**REQUEST**

Current Zoning: I-1 and R-22MF (general industrial and multifamily residential)  
Proposed Zoning: UR-2(CD) (urban residential, conditional)

Approximately 1.1 acres located east of Turner Avenue, west of Bacon Avenue, and south of Rozzelles Ferry Road.

The petition proposes to develop vacant property in the Seversville neighborhood with up to 15 single family attached units at a density of 13 units per acre.

RZ-1.0

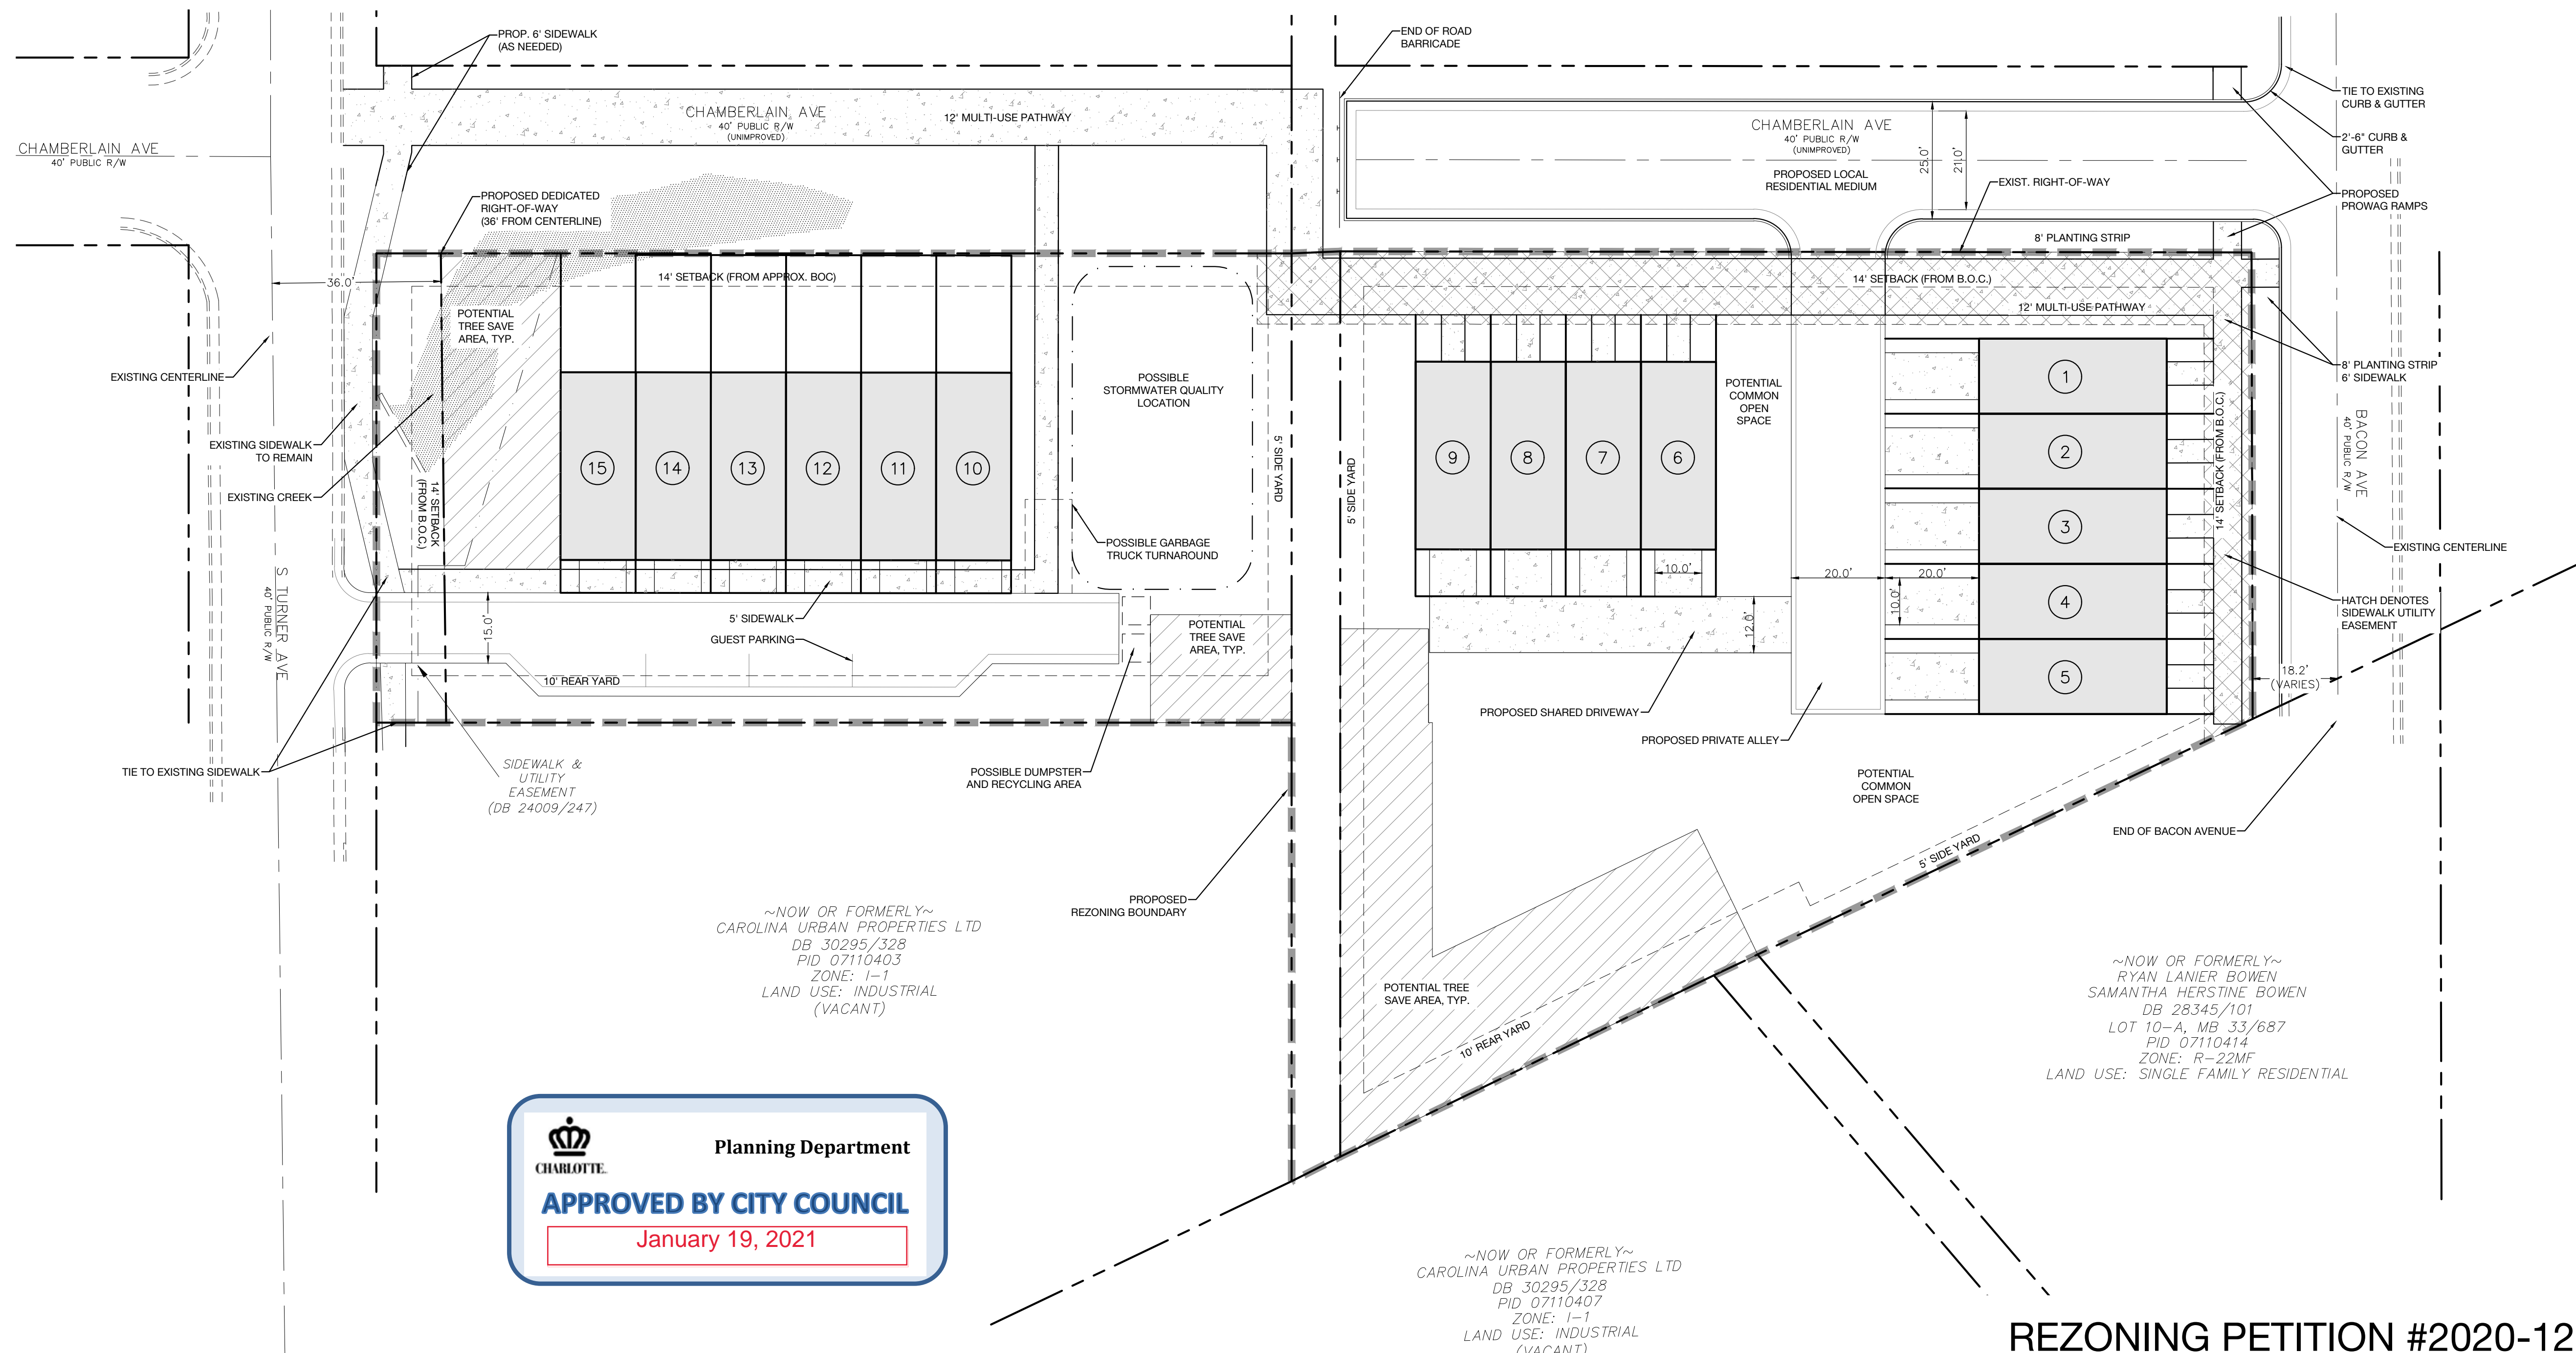
1. Add floor area ratio allowed and proposed to site plan.
2. Address how trash and recycling will be handled. Trucks cannot back out onto a public street. Either add a turnaround or use smaller dumpsters on wheels that can be rolled to S Turner Avenue for staging on a dumpster pad.
3. Clarify max building height for structures is capped at 40'.
